From: Joyce Christie
Sent: 06 May 2025 15:30
To: Shona King
Cc: DC Support; Nathanael Stock
Subject: 25/00527/DISC North Arms

Discharge of Condition 9 (details of structural opening) of 24/01880/LB

SCALE	DATE	DESIGN/DRAWN	CHECKED	APPROVED	SHT
1:100	APR. 2023				
22070					
22070/P11					REL. D

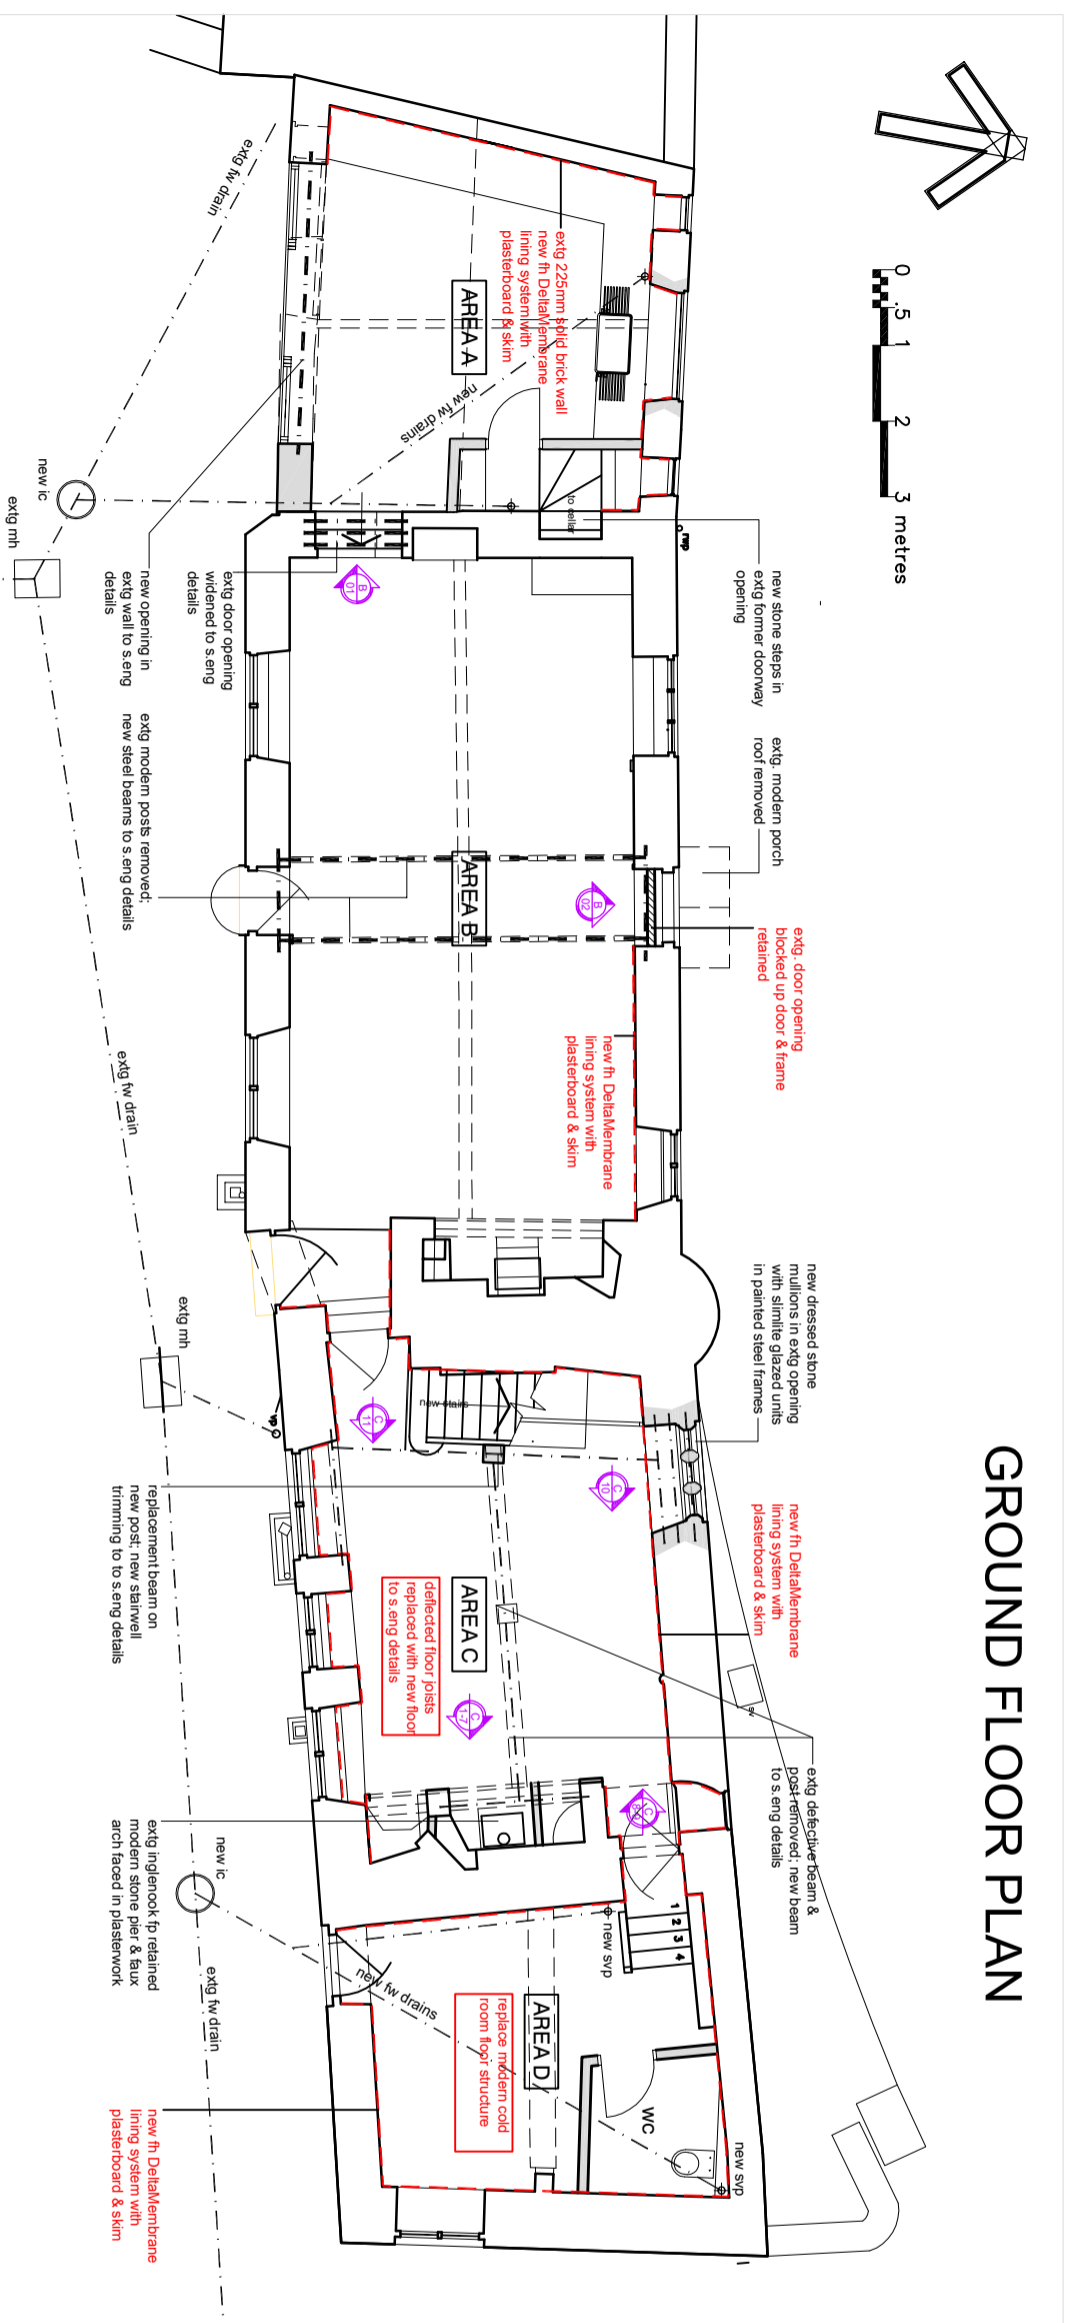
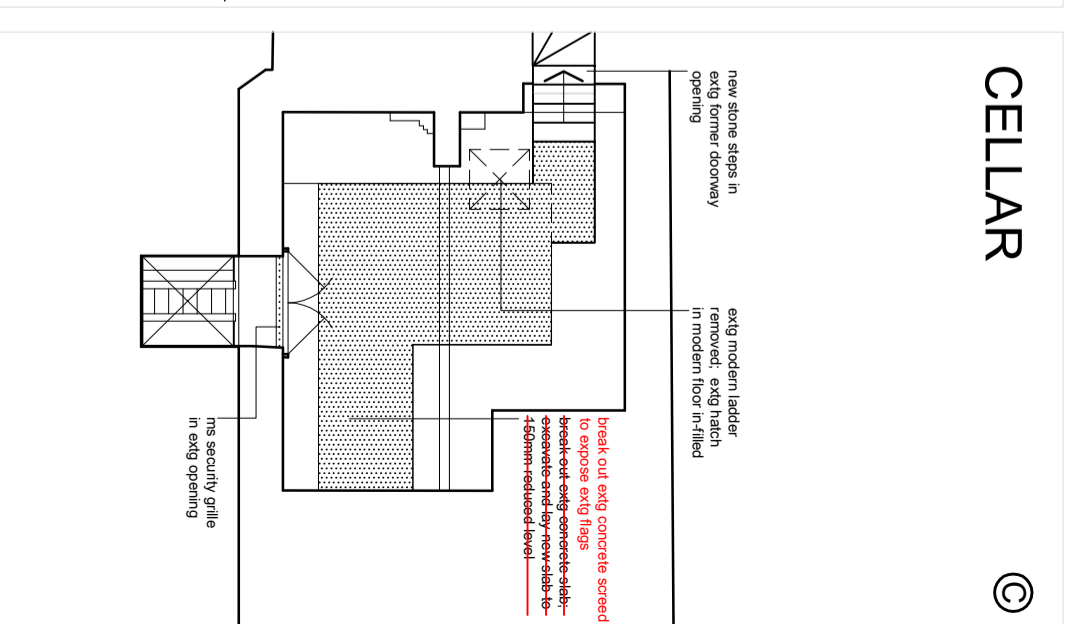
P11D shows the whole floor plan. Drawings 12C and 13B were also submitted but these are not relevant to Condition 9 of 24/01880/LB.

P27
 Please ask for a bit more information on Drg P27 to show the existing floor slab junction with the new floor slab and how the ceiling finishes between the existing and proposed relate to one another. Please also confirm how the new steel that is to be inserted to support the ridge of the new roof will be embedded in the masonry. Can they supply further detail on the junction between the extension roof and the stone pier between the large opening and the door. Please note Drg P11D and P27 are different as P11 doesn't show a door and appears to show a wider opening?

Drawing P11D continues to relate to the original approval ref.: **22/03307/F & 22/03308/LB** in order to highlight the variations, as now requested. Drawing P27 relates to the subsequently Consented kitchen extension ref.: **24/01879/F & 24/01880/LB**

Response:
Floor – agreed.
Purlin steels – agreed.
P11D and P27 – noted.
